**Application** H14-0165-21  
**Location** Land off Wardentree Lane Pinchbeck Spalding PE113UG  
**Proposal** Erection of 96 dwellings and associated works - outline approval H14-0720-18

**Name** Angela Doherty  
**Address** Housing Strategy

**Date Submitted** 28-06-21  
**For/Against** Comments

Drawing:
Planning Site Layout

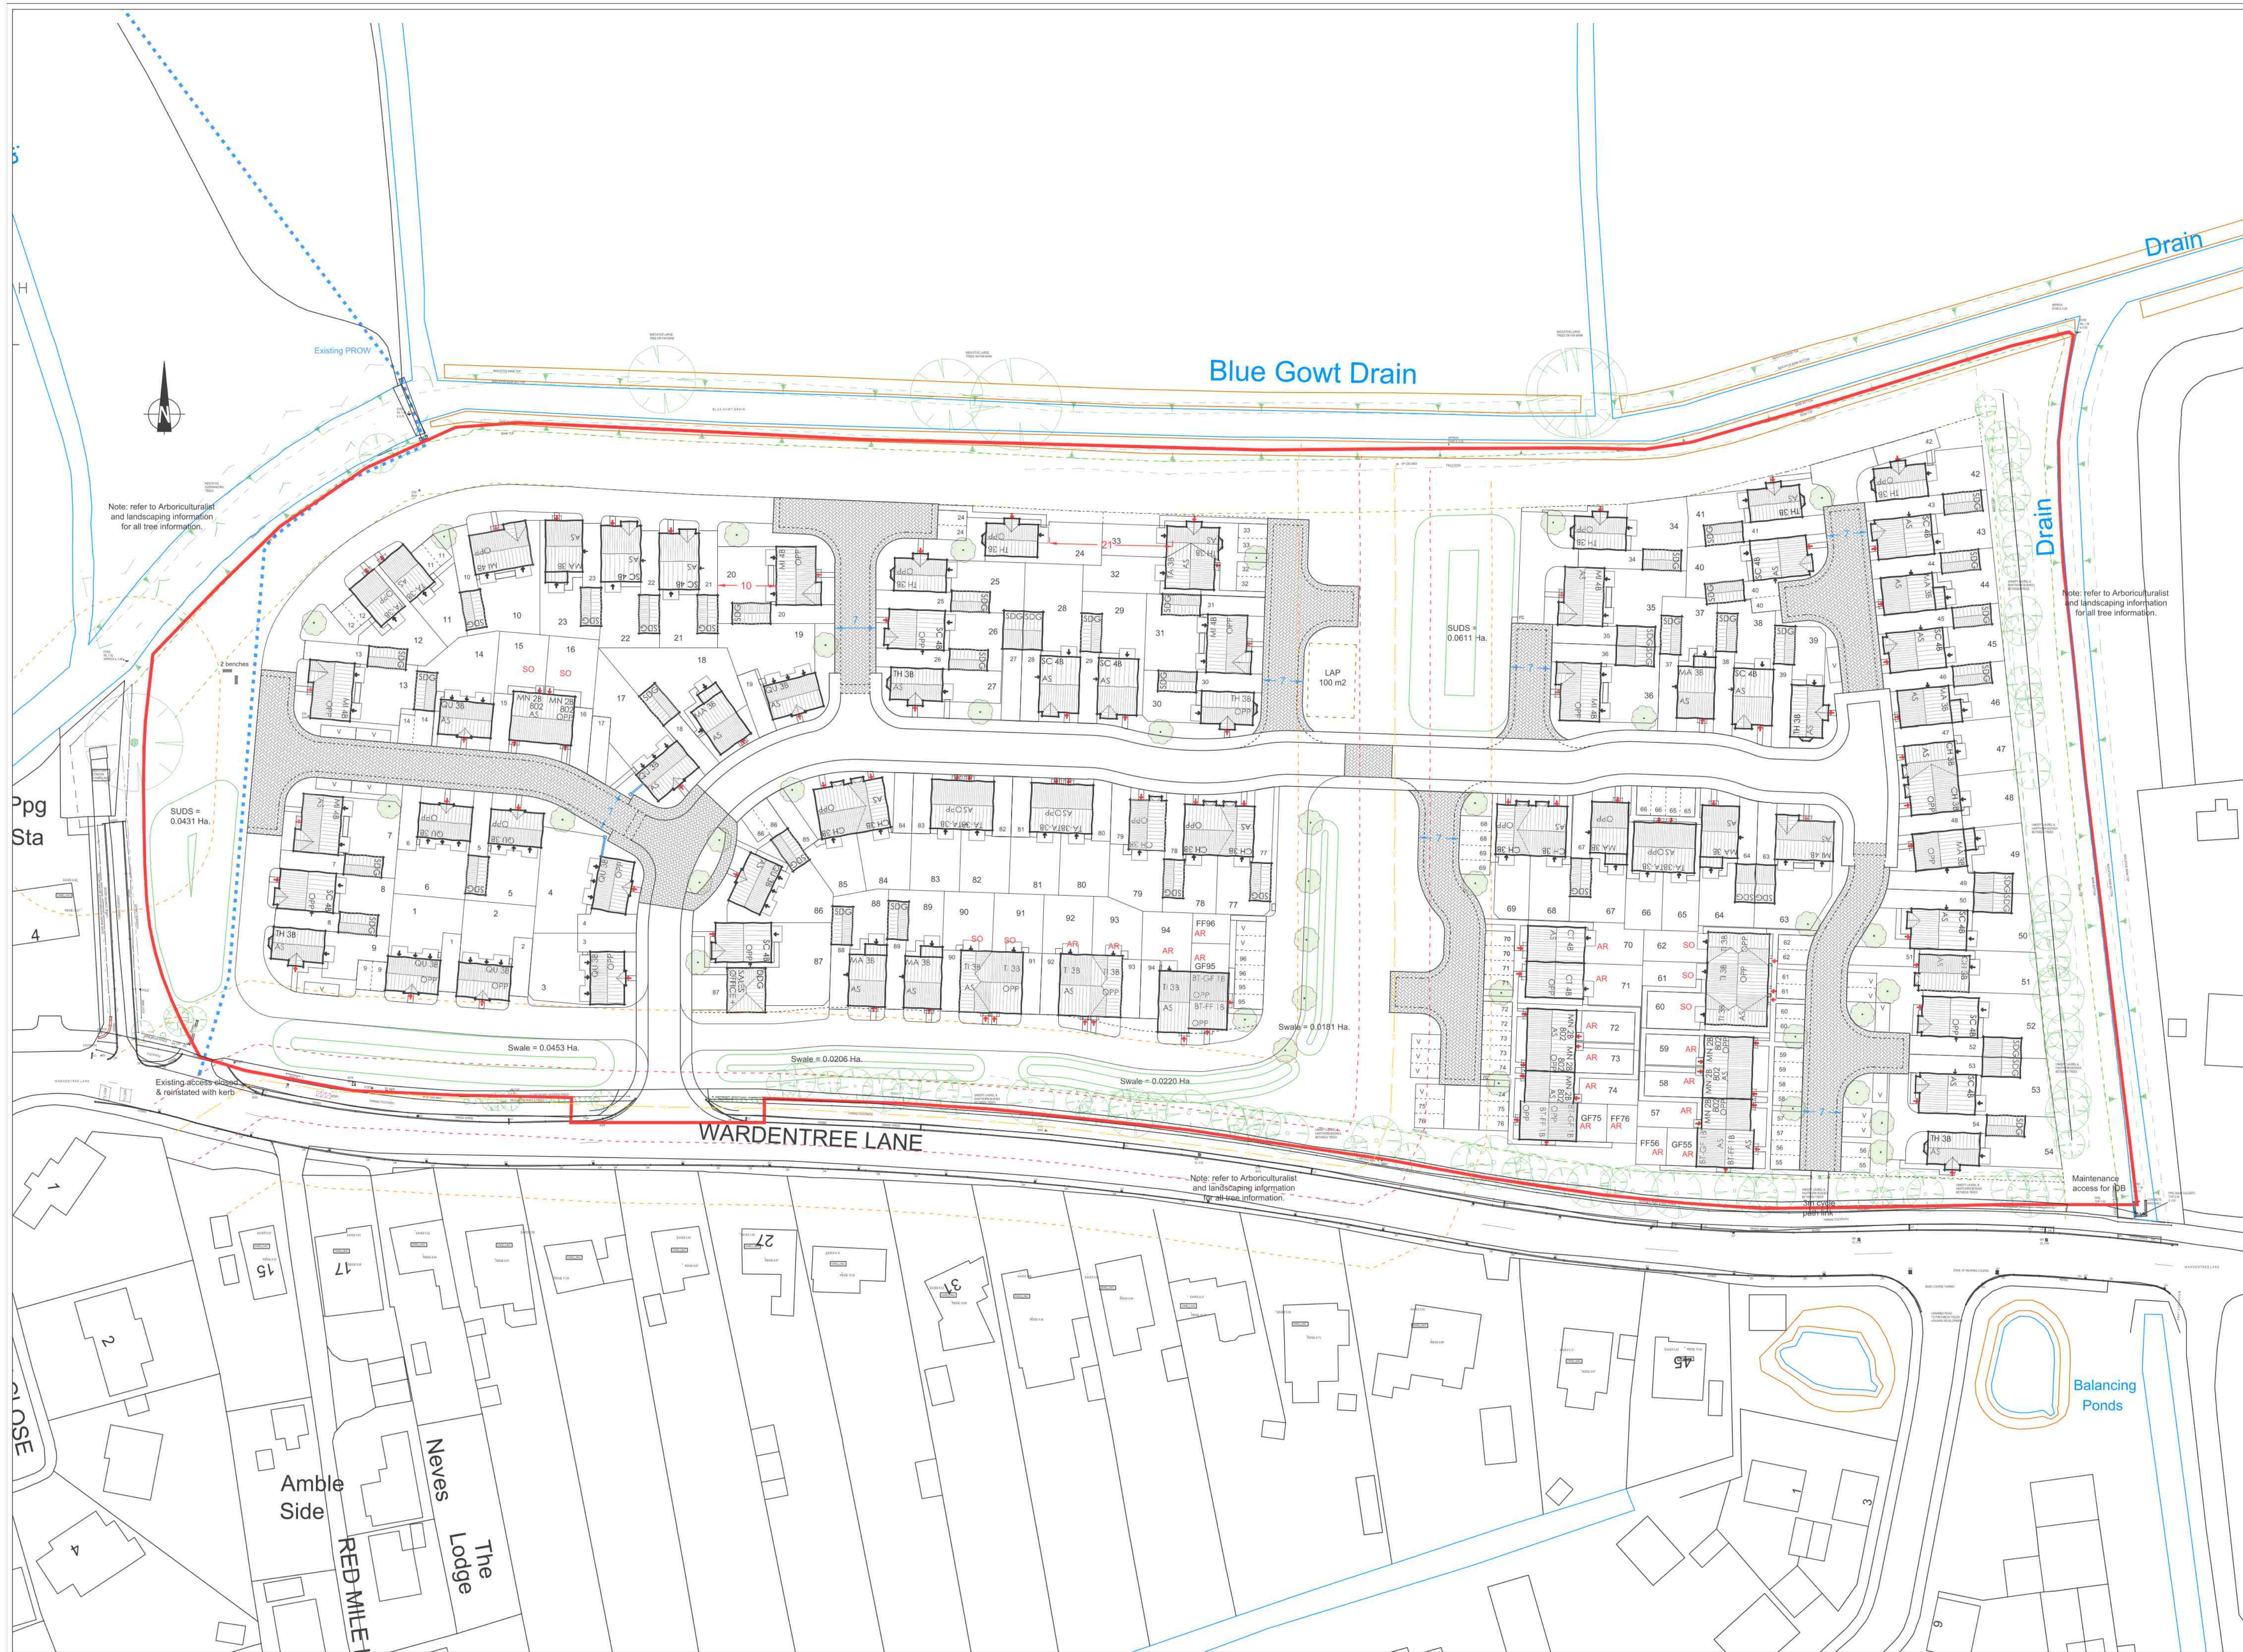
The applicant has amended the plans and now proposes 24 affordable homes, 17 for rent and 7 for shared ownership. This accords with the 25% affordable housing requirement with a 70/30 split in favour of rented as set out in Policy 18: Affordable Housing.

For the 17 rented homes the applicant proposes 6 x 1 bed maisonettes (plots 55,56,75,76,95,96), 6 x 2 bed houses (plots 57,58,59,72,73,74), 3 x 3 bed houses (plots 92,93,94) and 2 x 4 bed houses (plots 70&71). These proposed changes appear to address the concerns I had previously raised relating to 2 bed maisonettes being positioned directly above 1 bed properties. It is unclear from the plans but I would suggest that there are no communal areas indoors or shared gardens for the 1 bed maisonettes to assist with the management of these properties.

For the 7 shared ownership properties the applicant proposes all of these to be provided as 3 bedroom houses (plots 15,16,60,61,62,90,91), not taking into account the previous comments to diversify this offer with the inclusion of 2 bed houses or bungalows.

The s106 agreement relating to the Outline consent refers to the applicant submitting an affordable housing scheme for approval. I would expect the applicant to include alongside the affordable housing plan and the house type plan the details of the affordable homes as they appear to be missing, detailing the internal floor size of all of the affordable dwellings. Can we please ask the applicant to provide this? The applicant also states that all homes meet M42 standards, so suggest this is verified as that would assist in meeting homes that are suitable for adaptation over time.
